**Environment, Planning and
Enforcement**

14 June 2019

**Re: Application by RiverOak Strategic Partners for an Order Granting
Development Consent for the upgrade and reopening of Manston Airport
– Deadline 8**

Manston - Haine Link
Land for Safeguarding
Sheet 1

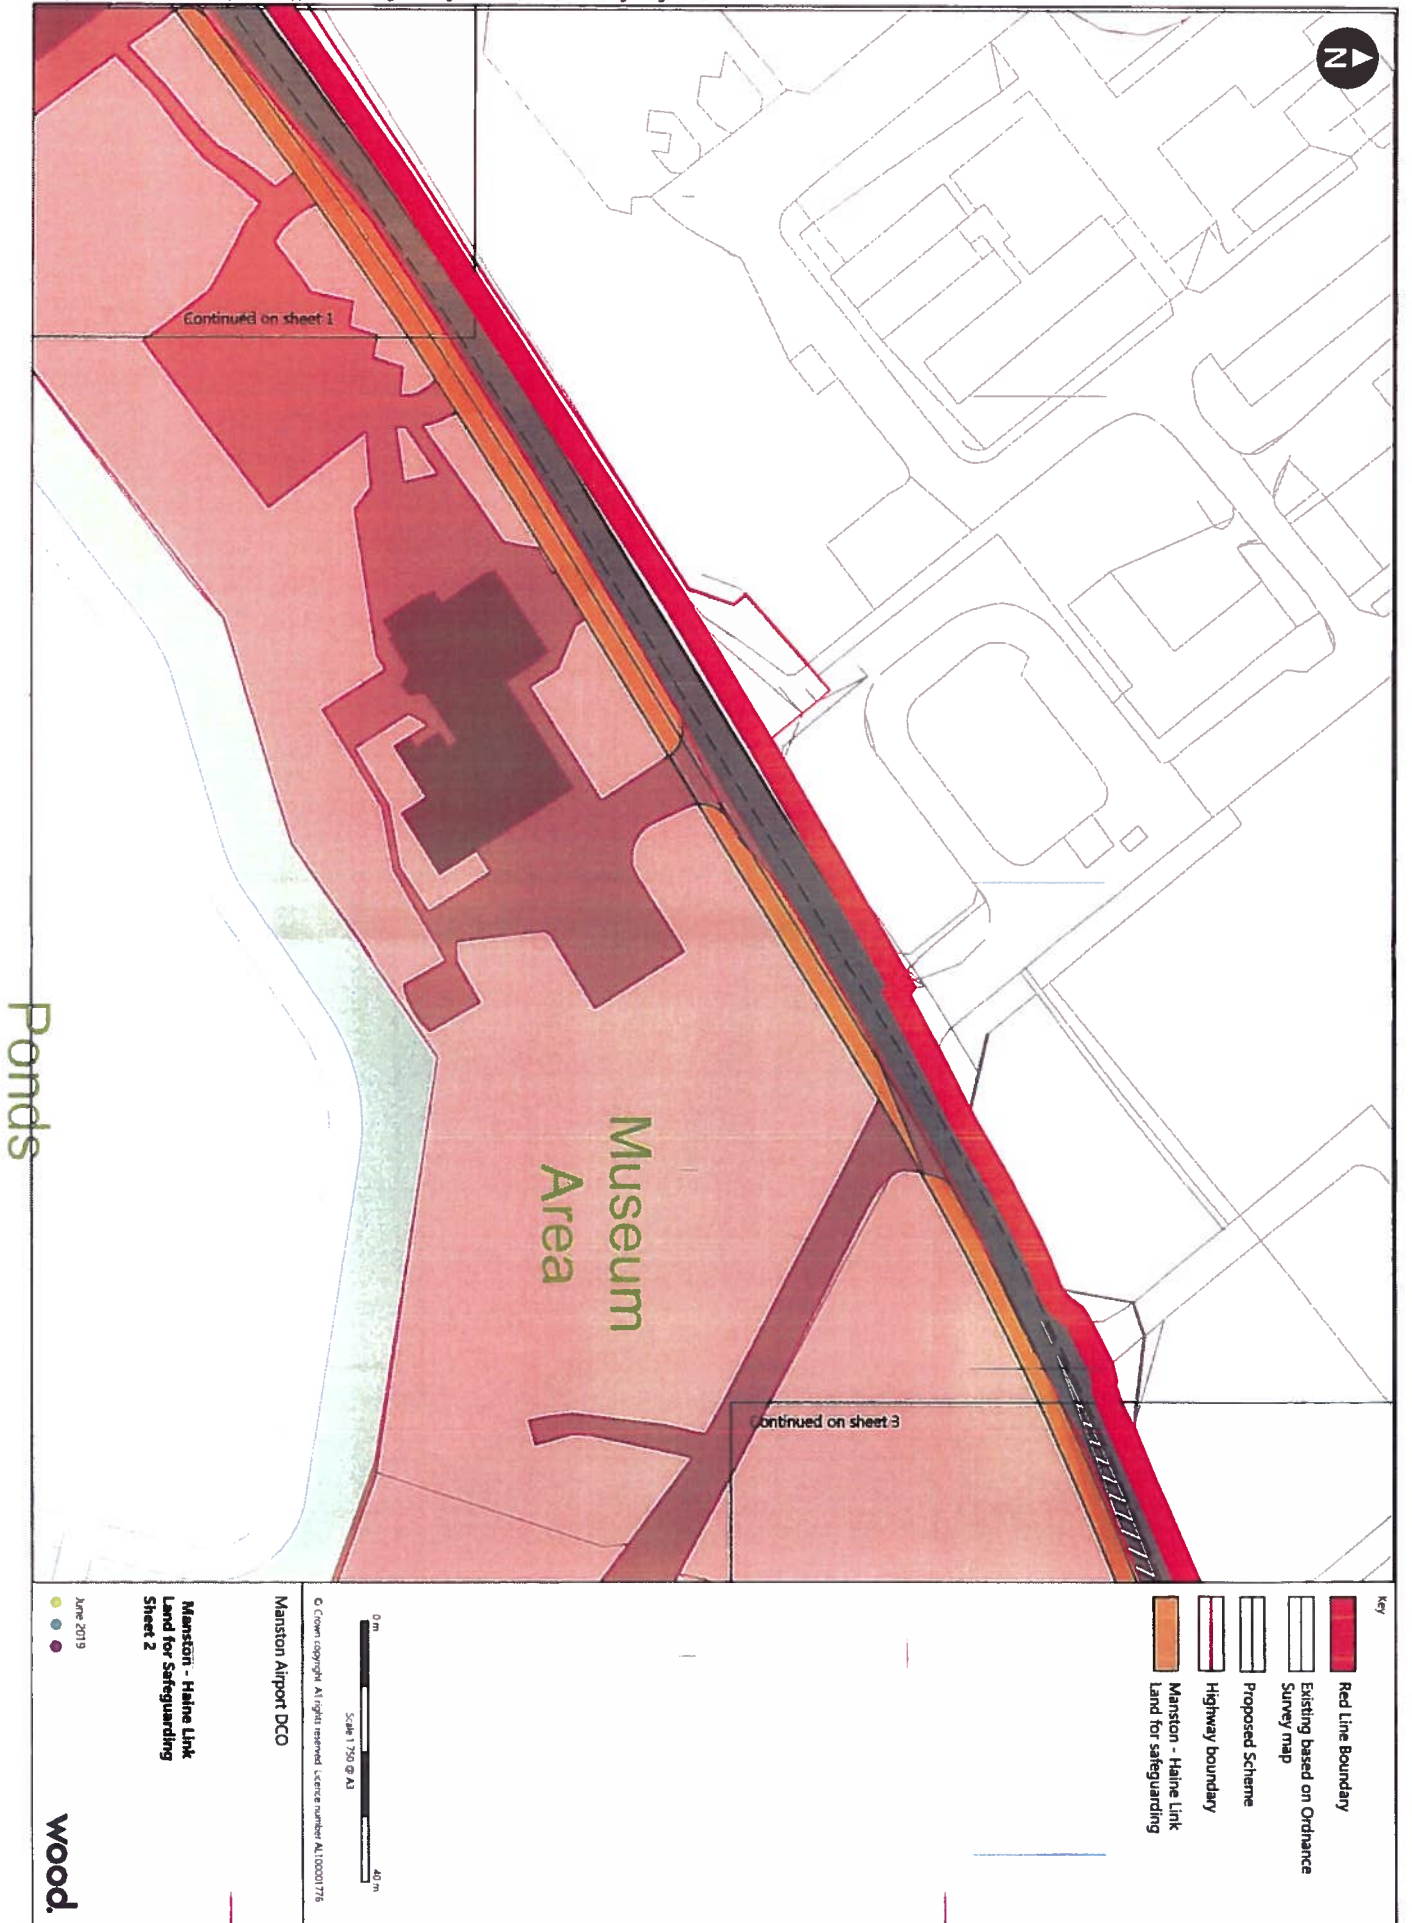
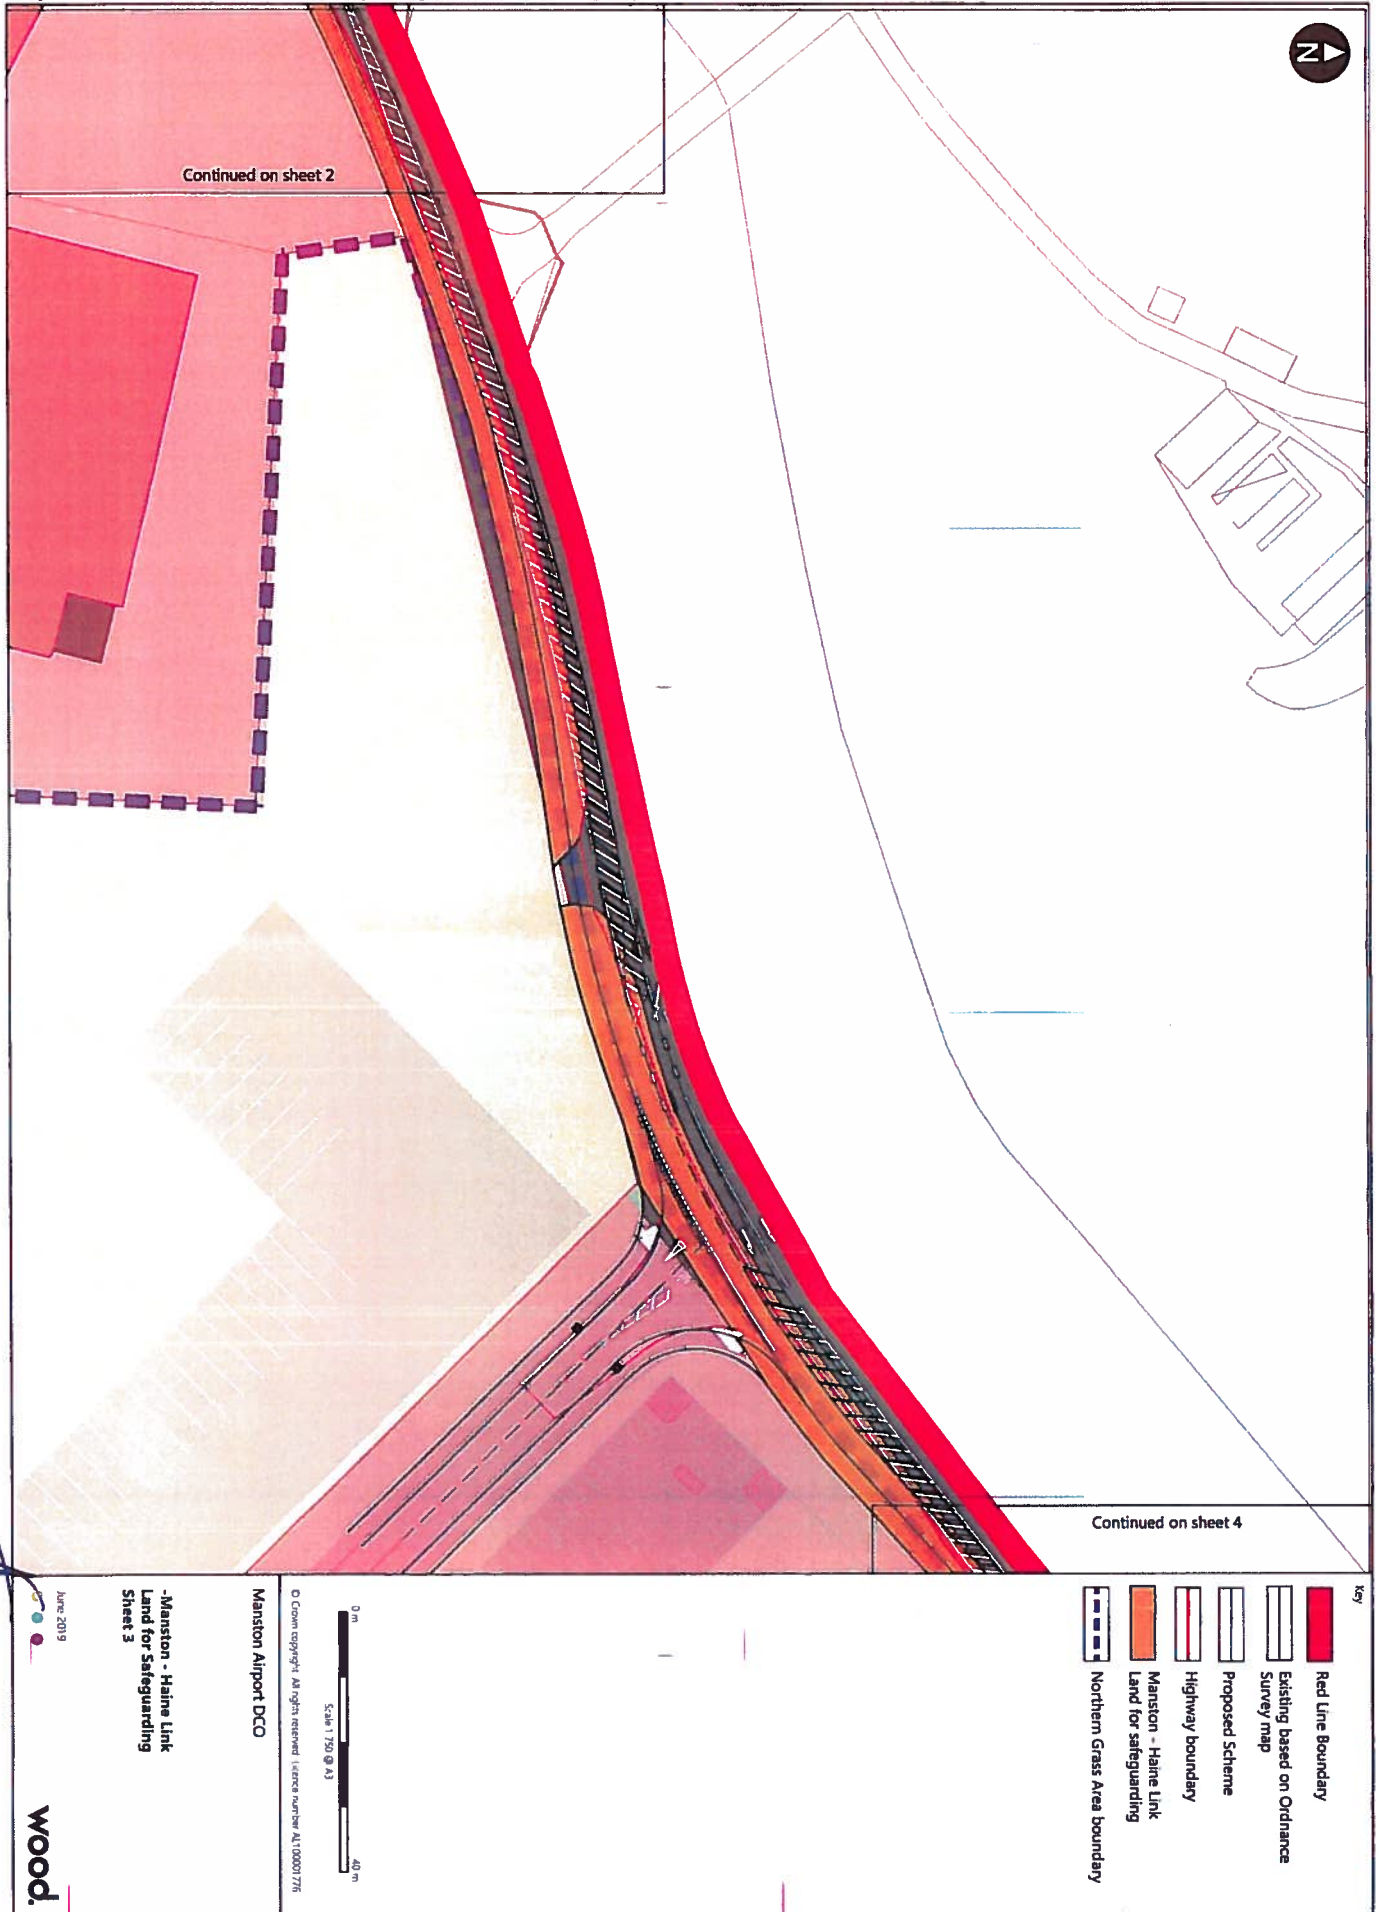
- The road link is currently at a very early stage of development and is based on a two-dimensional design. Therefore, defining a precise area of land for safeguarding (based on this early stage design) offers insufficient flexibility to KCC, should it need to react and accommodate possible minor changes in alignment and subsequent land requirements as the design progresses.

- Until potential land requirements are known in full and features such as drainage and archaeology are identified, it is essential that a level of flexibility is maintained to allow KCC to accommodate any changes that may be needed as a result, in a similar way to that sought by the applicant for the proposed development of the Northern Grass Area.

- The current safeguarding area provides no scope whatsoever for any minor realignment, provision of a turning head for the proposed Manston Road service road, or any form of junction at Spitfire Way, which is a significant risk from the Highway Authority perspective.

- Safeguarding must include all land between the existing highway (Manston Road) and the western side of the proposed link and all identified intervisibility areas on the eastern/southern side of the road to make the scheme acceptable.

- Land required to deliver a new Junction at Spitfire Way/B2050 Manston Road must also be included to enable the scheme to come forward ahead of

As outlined above, the proposed area of land for safeguarding is not yet agreed and will require further dialogue between the applicant and KCC in due course.
